SSD 61400212
AB7 (P&E)

STATE SIGNIFICANT DEVELOPMENT APPLICATION 61400212
APPLICANTS: Third.i Crows Nest Residential Developments Pty Ltd

Sheet title  
CARPARK LEVEL 05

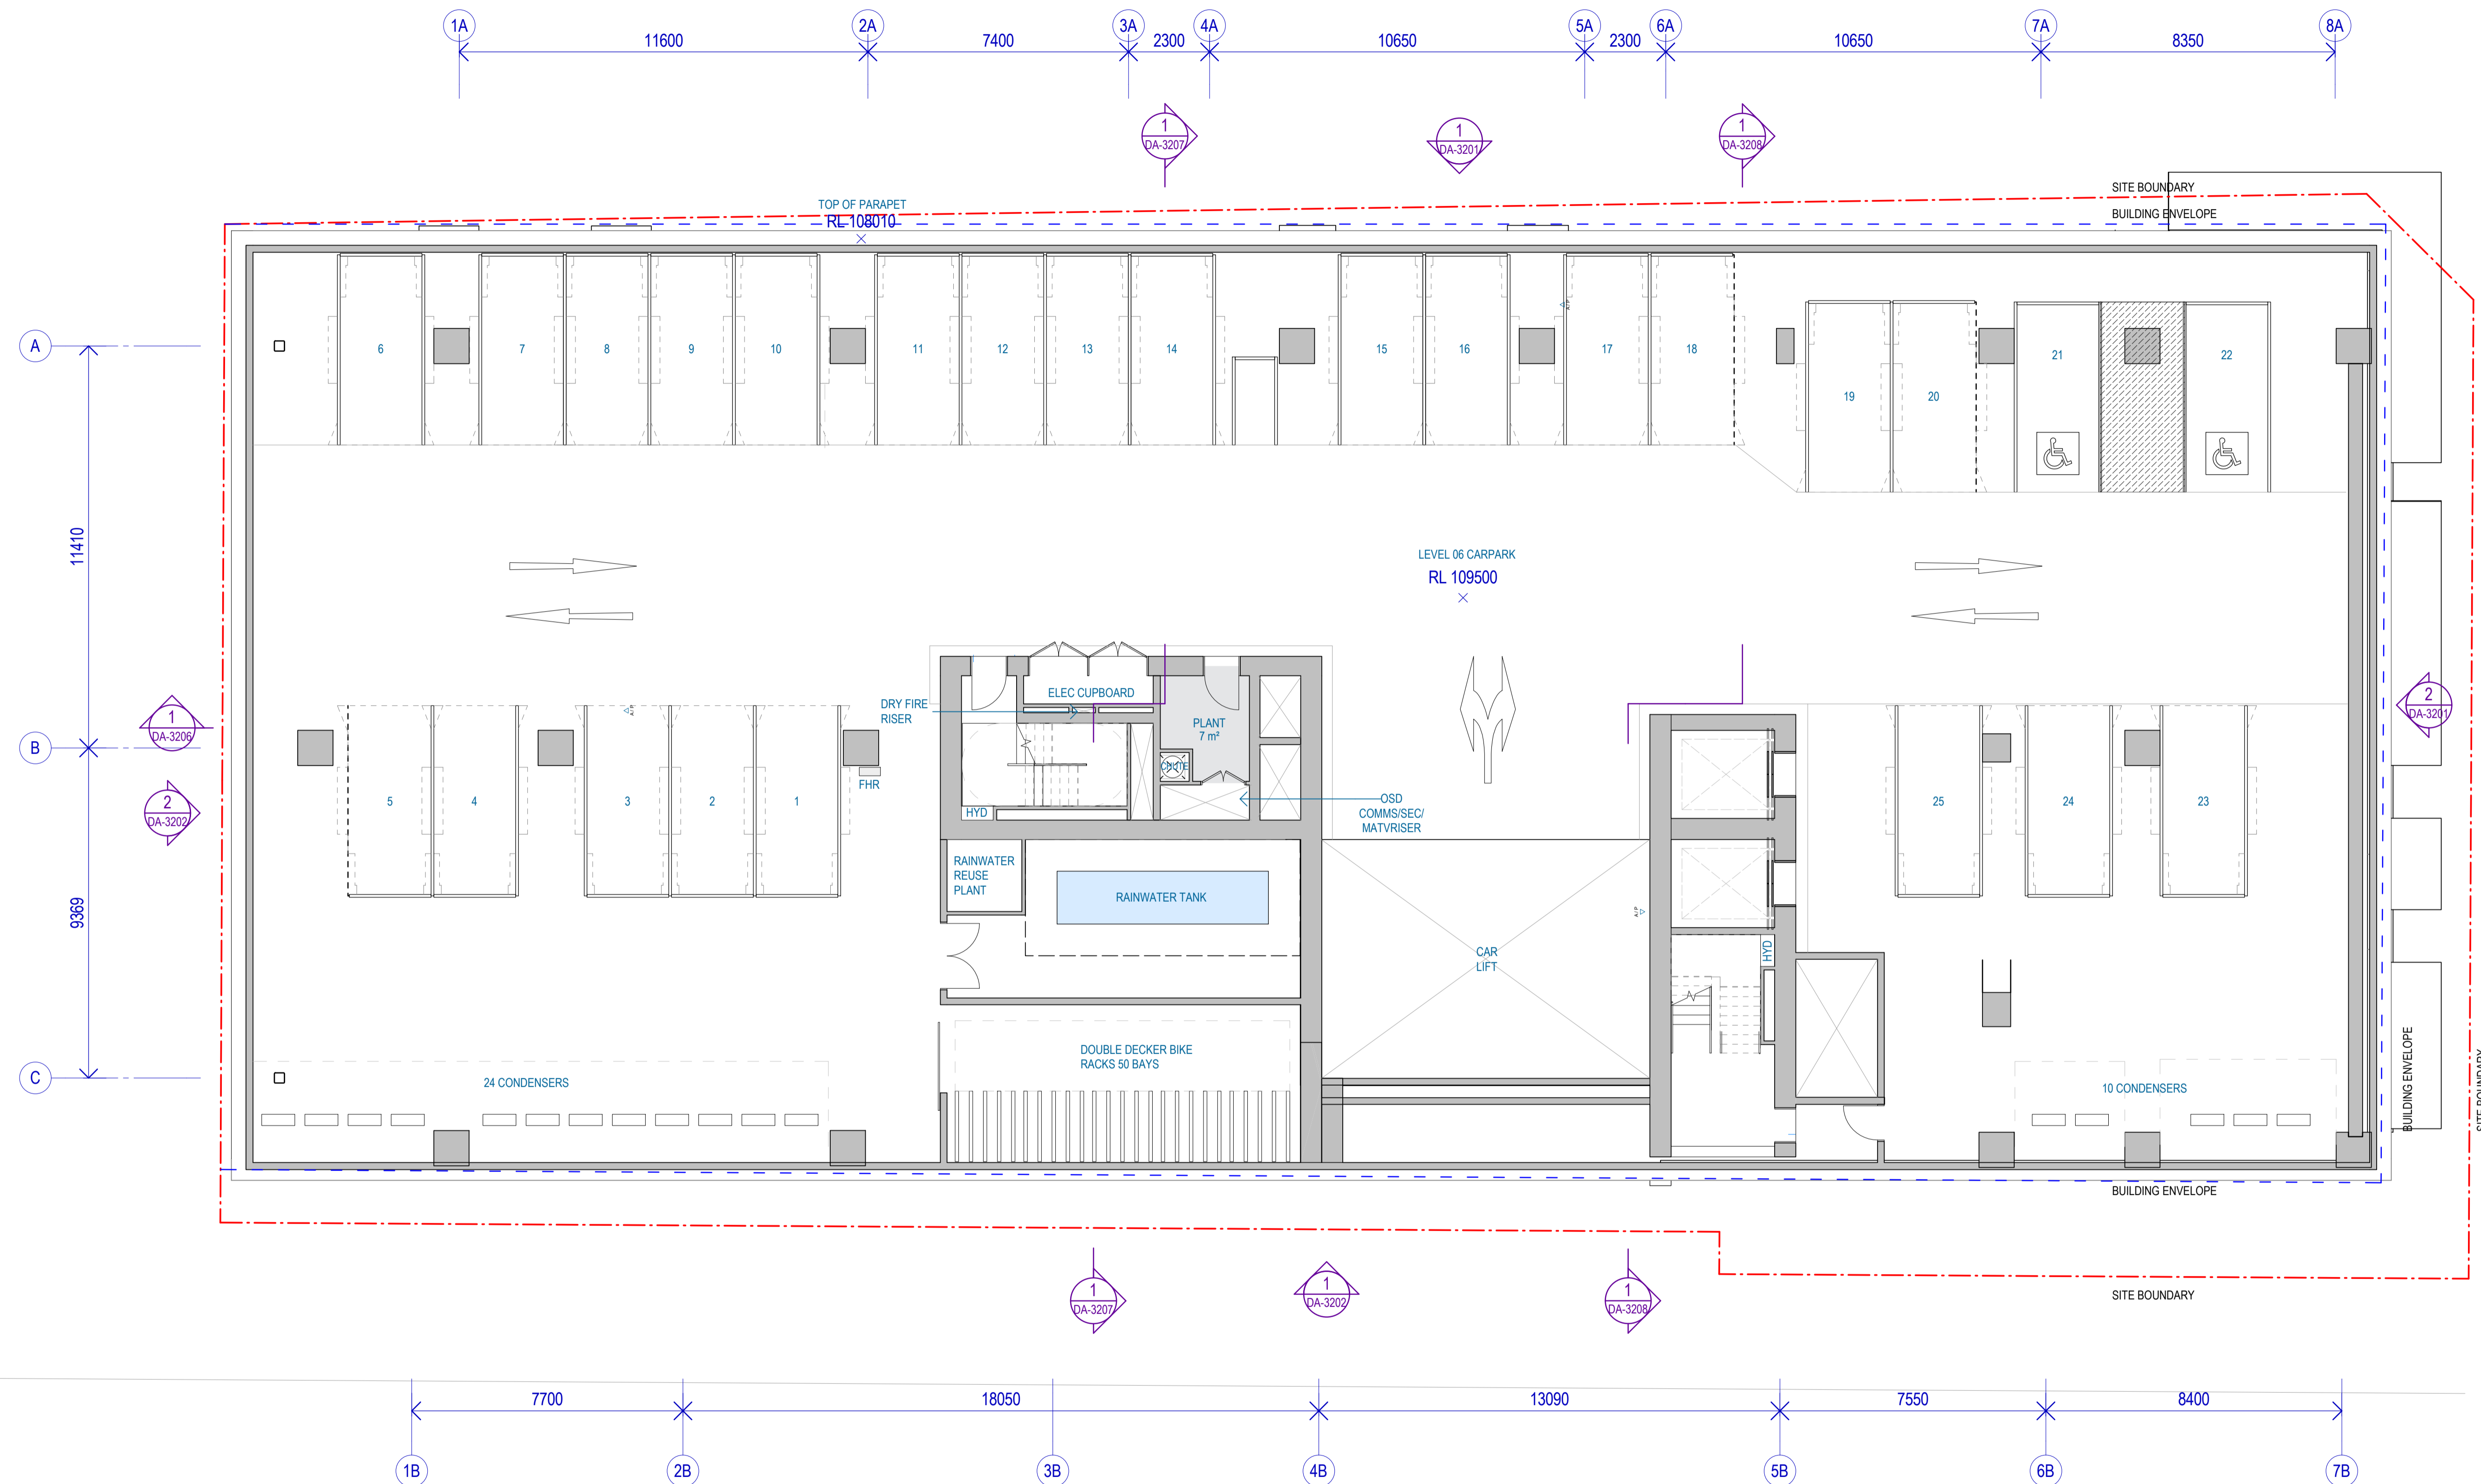
The proposed building includes two levels of car parking on Levels 5 and 6, with a direct open interface to the adjacent site to the south and a 0m setback to the shared boundary (Figure 7). The façade at this interface is designed as an open structure, featuring perforated metal panels.

The Crows Nest TOD planning recommendations indicate that the adjacent site is intended for redevelopment with a 3-storey street wall accommodating non-residential uses, with residential uses above. As such, the proposed open façade car parking levels with a nil setback at Site B will directly face future residential units on the adjacent site.

This design raises significant concerns, as it would have a detrimental impact on the residential amenity of the adjacent site, particularly in terms of privacy, noise, air quality and visual intrusion.

Sheet title	Sheet number	Revision
ELEVATIONS	DA-3201	B

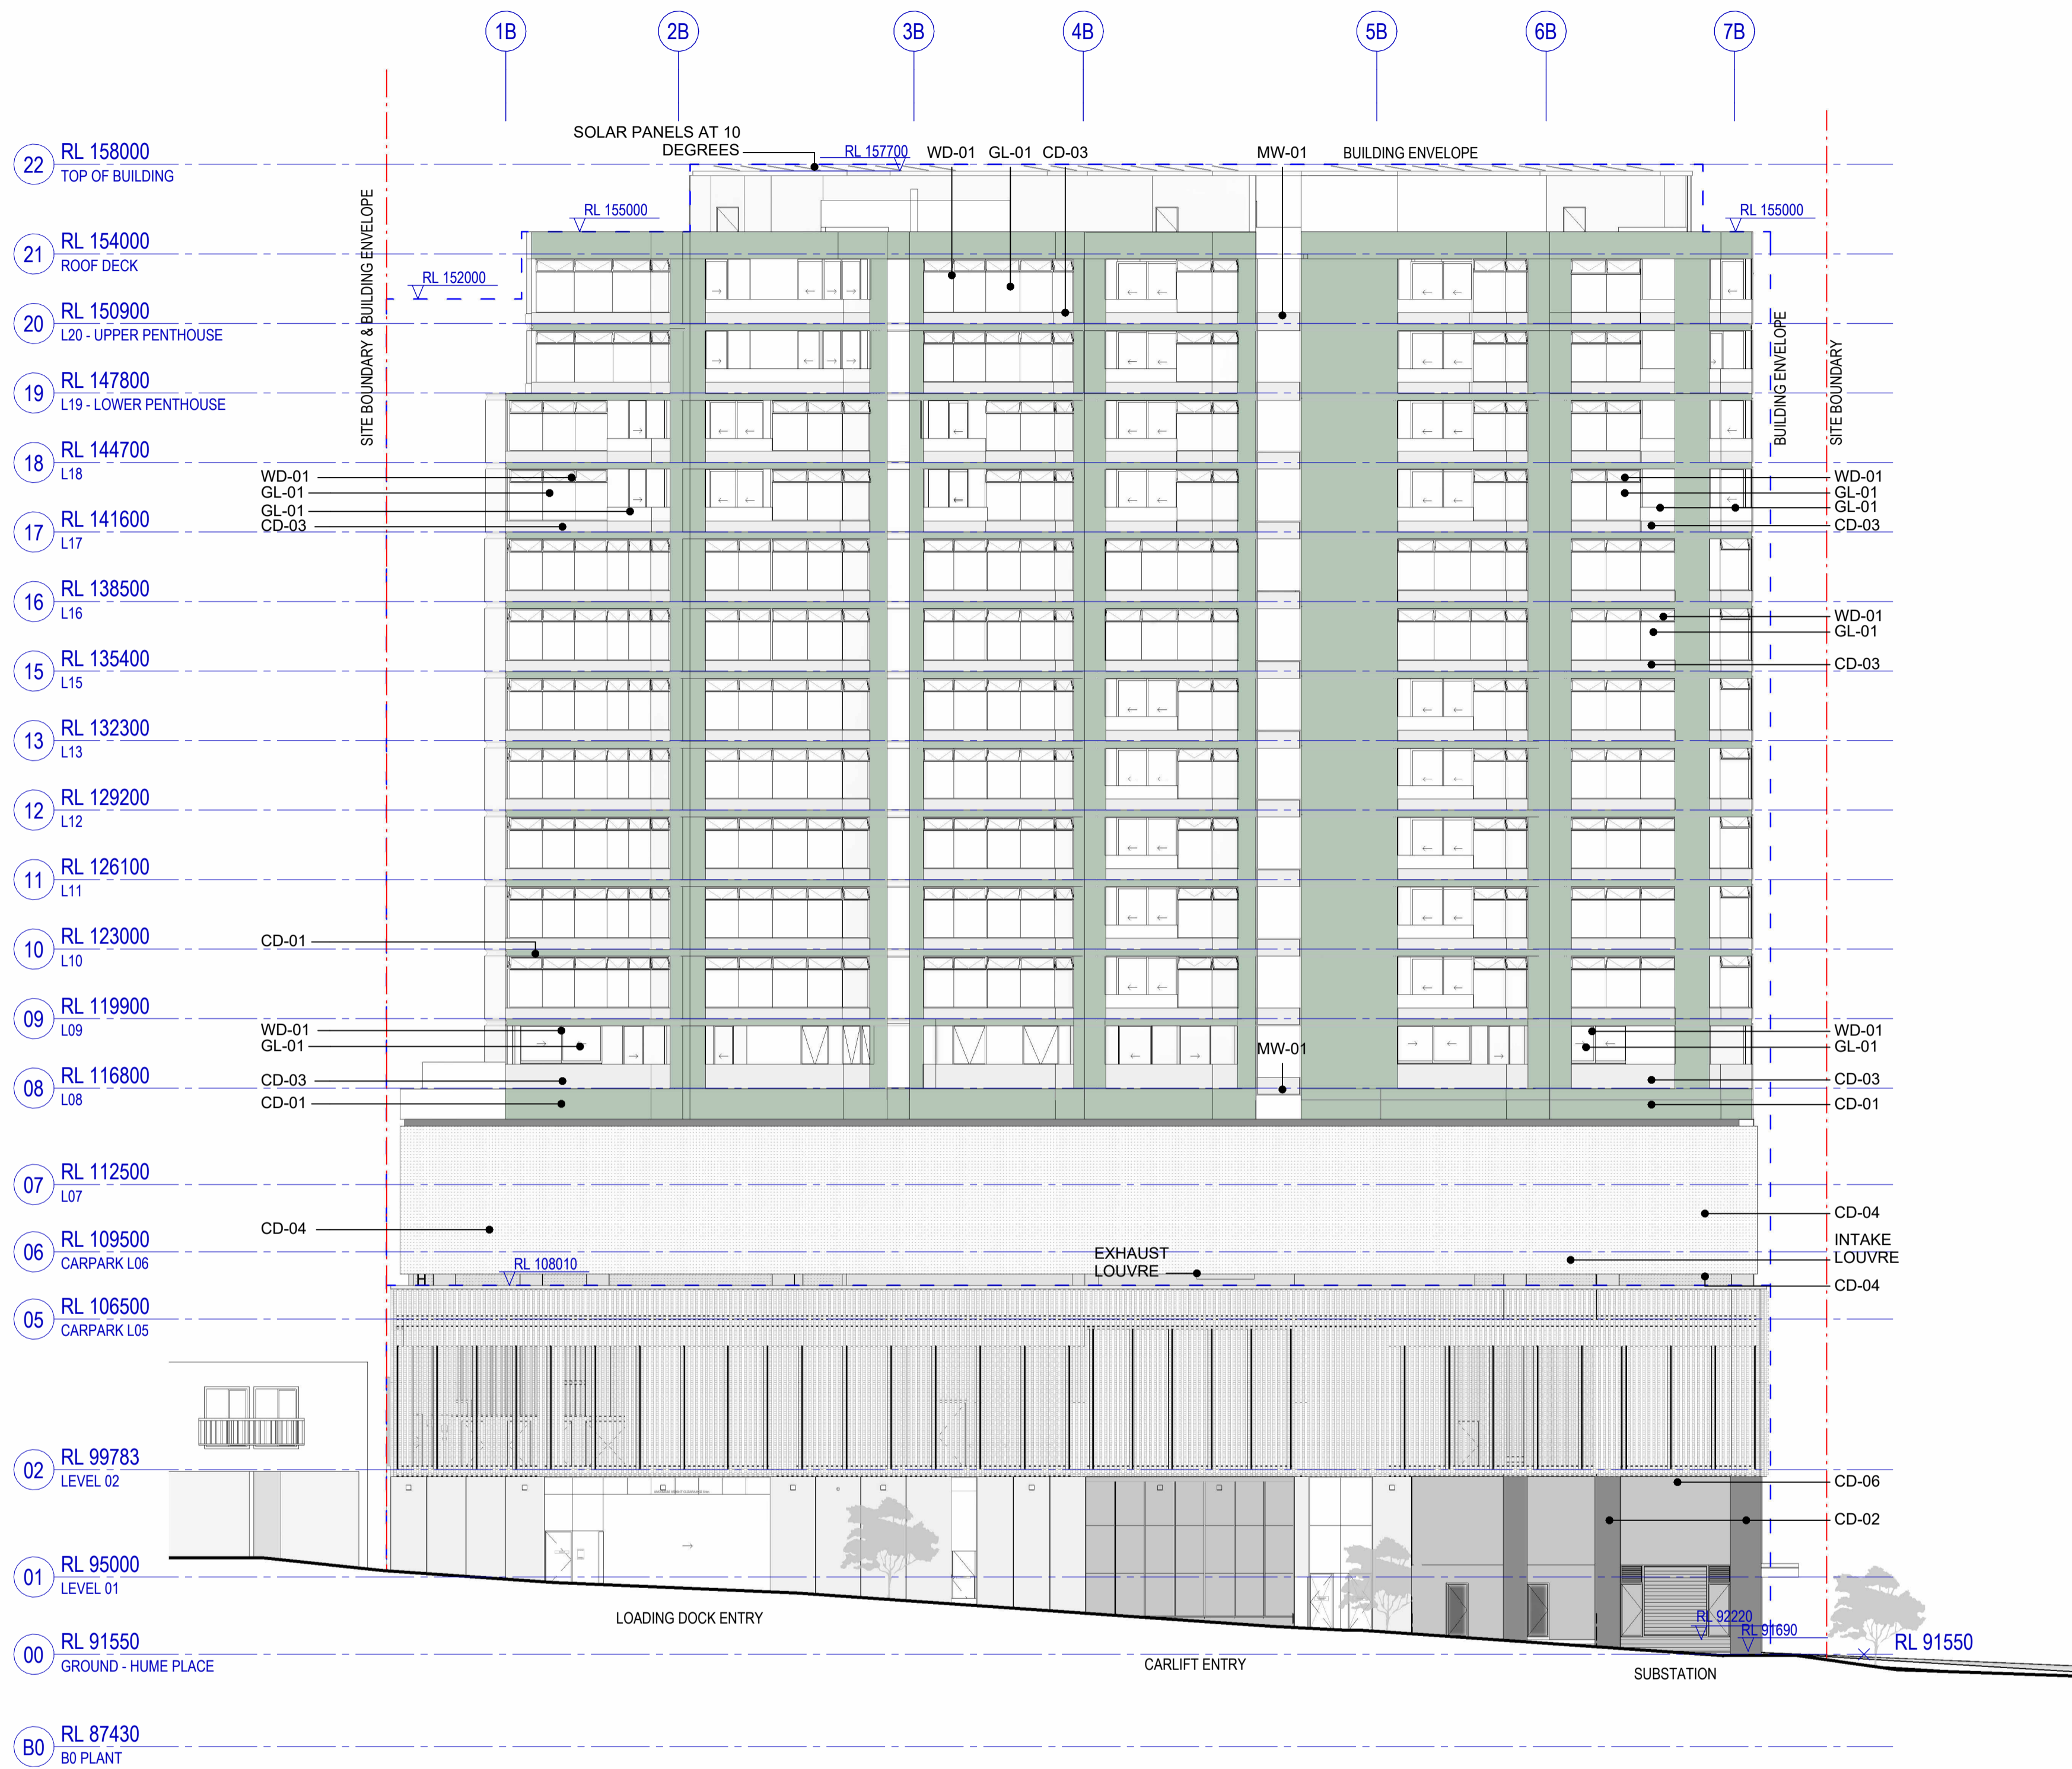
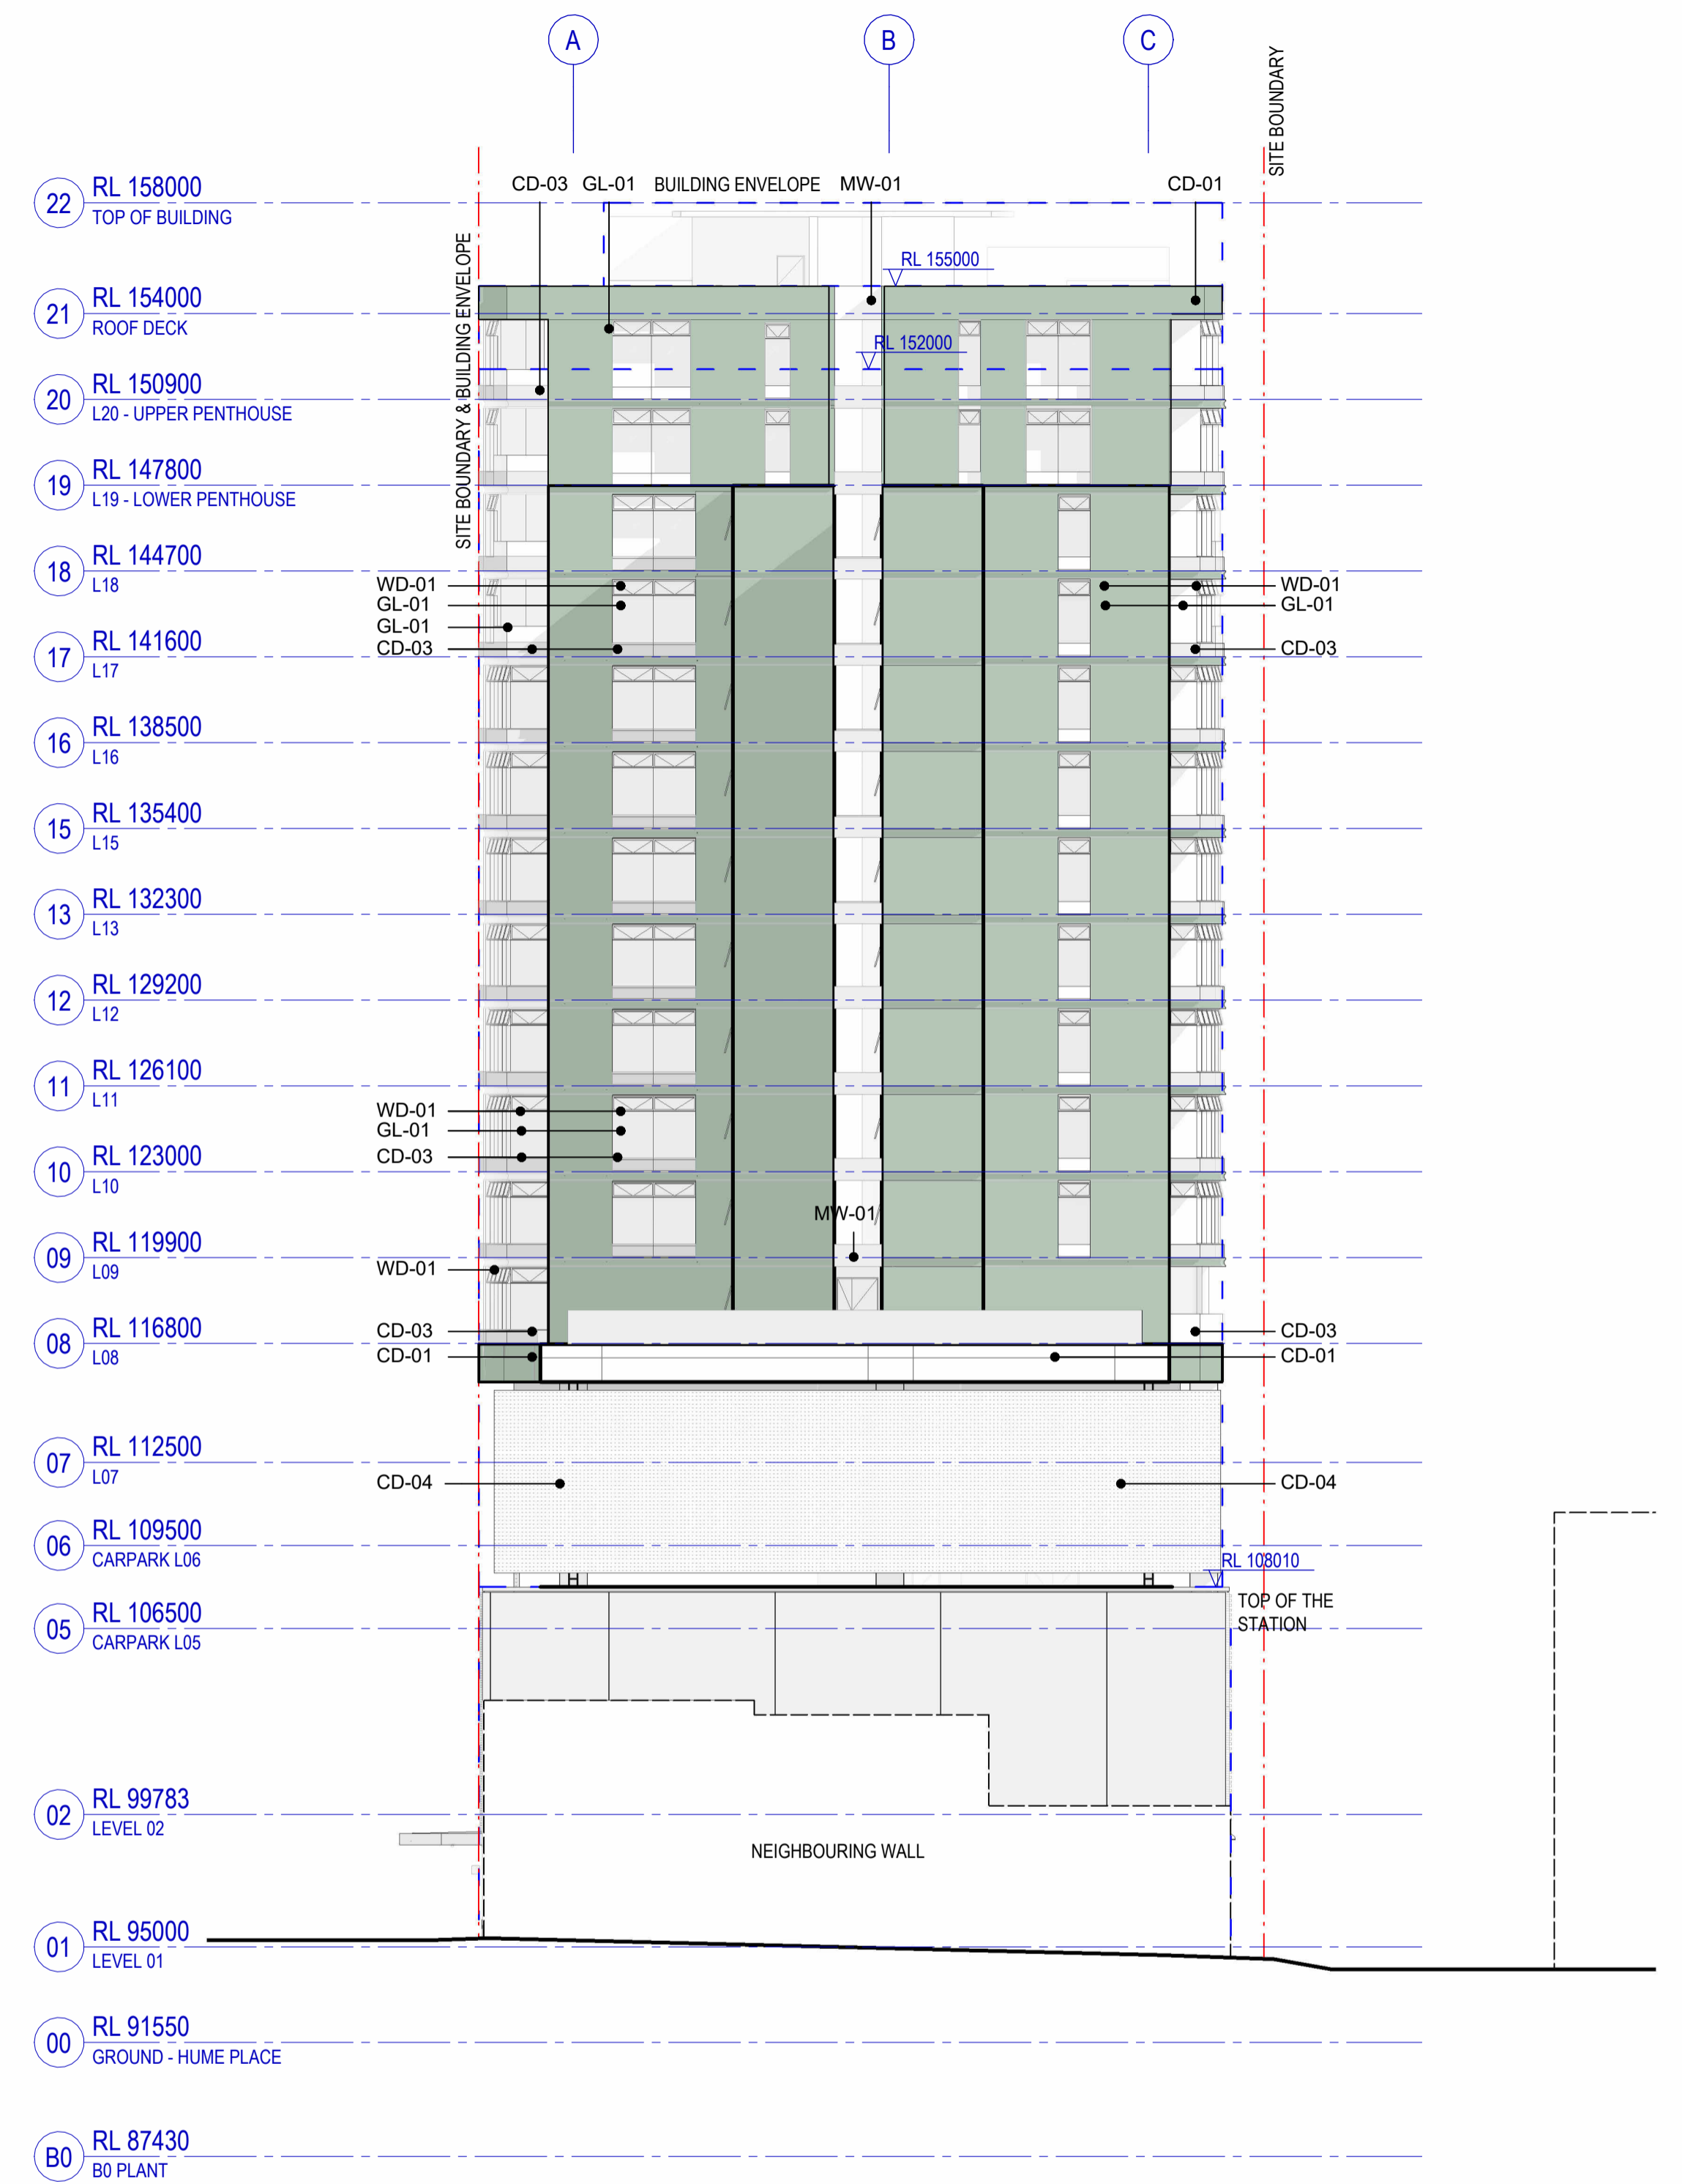
The proposed Site B building provides a setback of approximately 5–6.285m from habitable rooms to the southern site boundary for level 9-18, falling considerably short of the accepted minimum 12m setback requirement under the ADG and design recommendations of the Crows Nest TOD.

To mitigate these impacts and provide adequate amenity to the residential units, it is recommended that a minimum 12m building setback be provided by Site B along the shared southern boundary.
